From: Borough Planning
To: [REDACTED]
Subject: FW: 23/00007/F Sue Ryder 79 Westgate Hunstanton PE36 5EP
Date: 23 February 2023 11:33:16
Attachments: image002.png
image003.png
image004.png
image005.png

Subject: 23/00007/F Sue Ryder 79 Westgate Hunstanton PE36 5EP

Title:  
 SHOPFRONT DETAILS

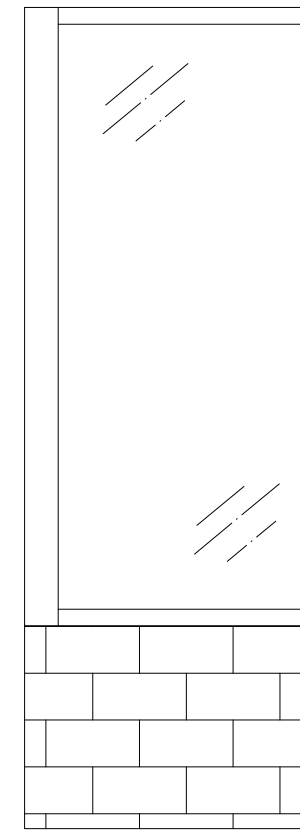
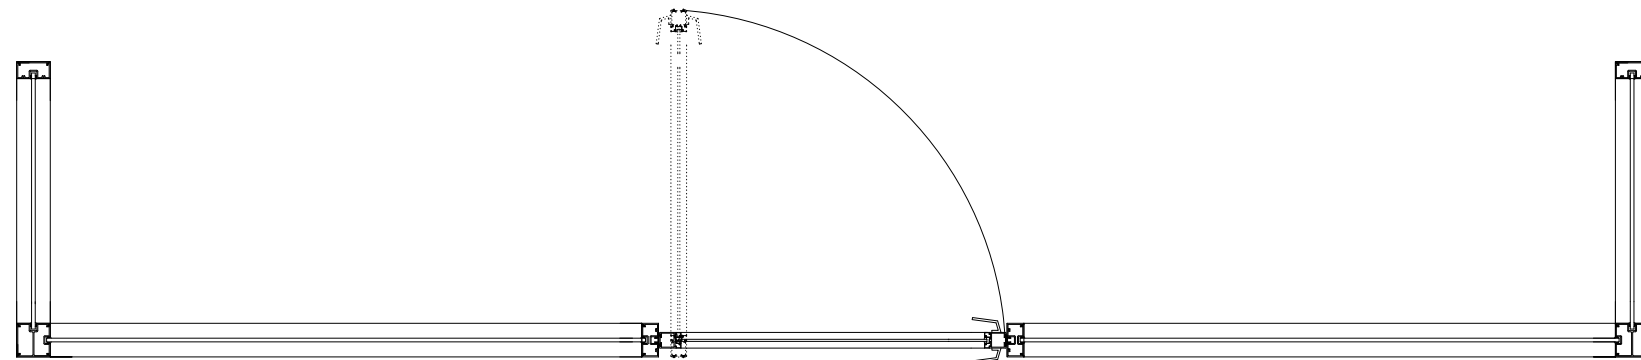
The plan states the scale is 1:20, and the width of the shop front is shown to be 4870. When I measure at 1:20 scale it comes out at 1.26

The side is shown to be 880. When I measure it is only 0.23.

I am sorry, but this plan is still not to scale. It may be the way its been saved or scanned.

I apologise for this. The application is invalid as the proposed plan is not to scale and I need confirmation that both side elevations are the same.
